Approved for access by the Solid Waste Department.

Reviewer: Herman Gallegos

Date: 03-13-24

SHEET TITLE:
SOLID WASTE PLAN

PROJECT NO.:	193806697	
DWN BY:	CHKD BY:	APPD BY:
HKK	JRA	CMR
ISSUE DATE:	04/24/2024	
ISSUE NO.:	3	
SHEET TITLE:	SOLID WASTE PLAN	
SHEET NO.:	C-602

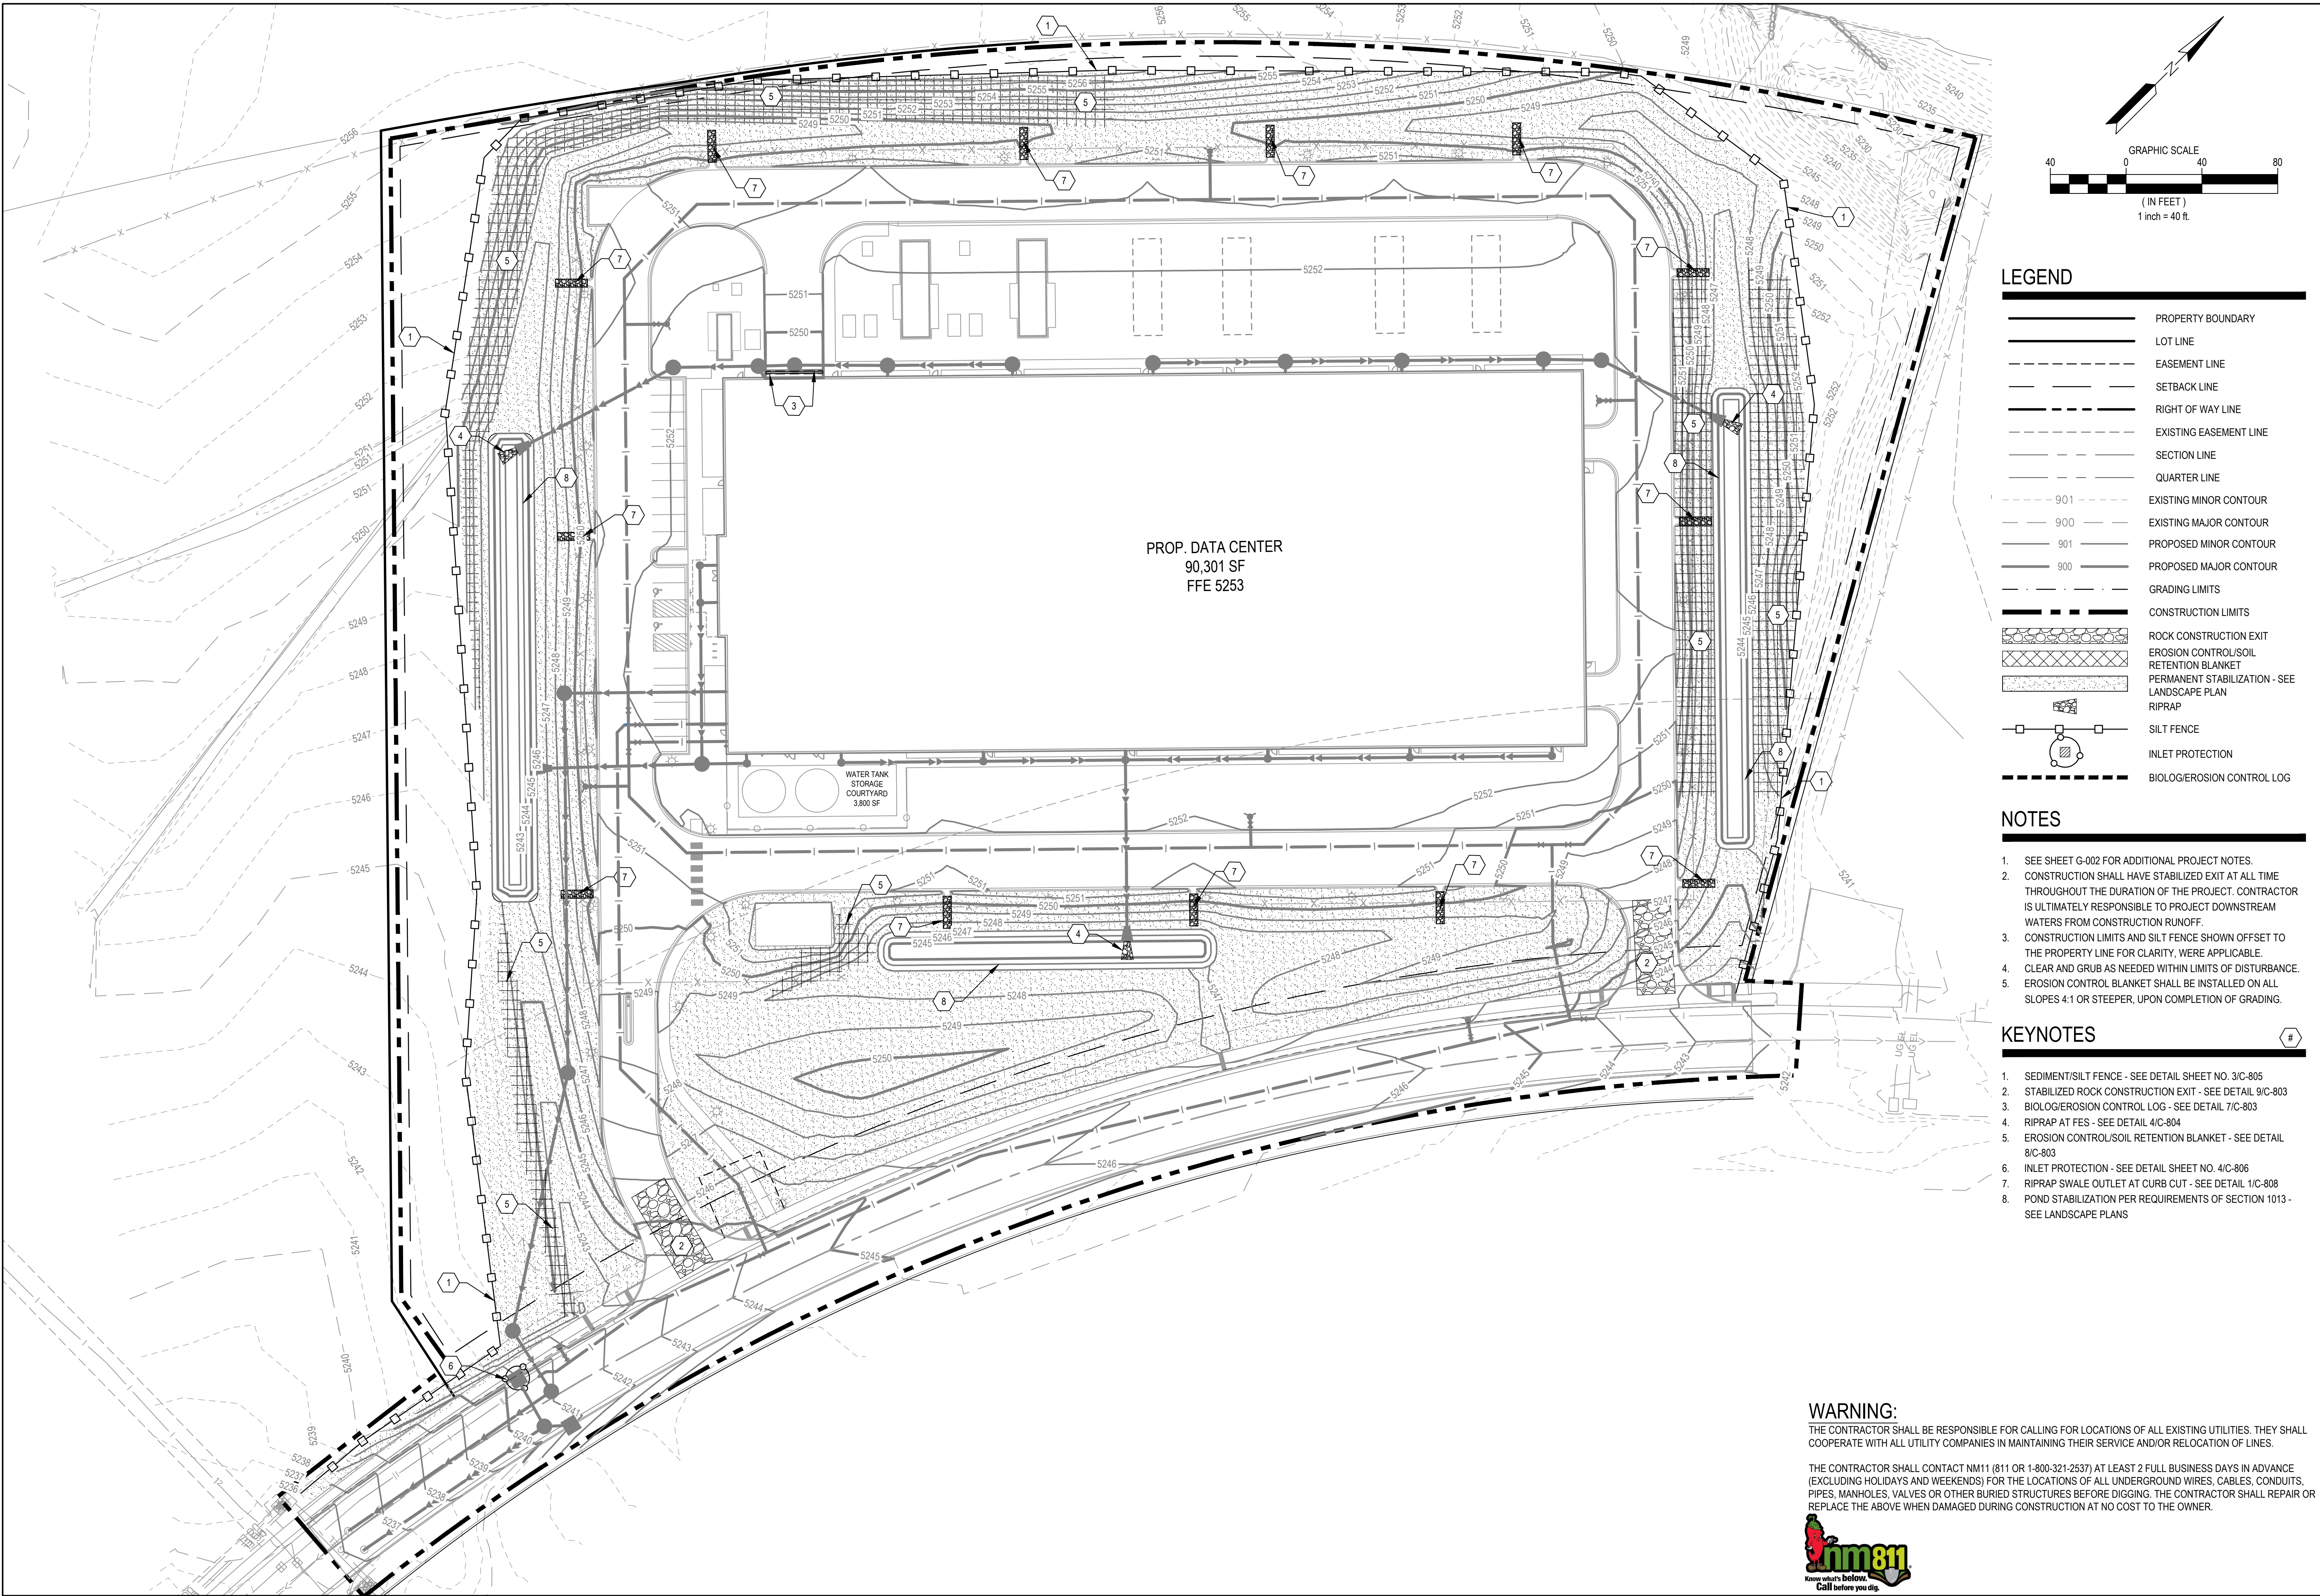
All containers must be made accessible for pick up

between the hours of 5AM and 8PM.

****Keycard access, security with an intercom.****

****Rolling access gate will open 30' clear.****
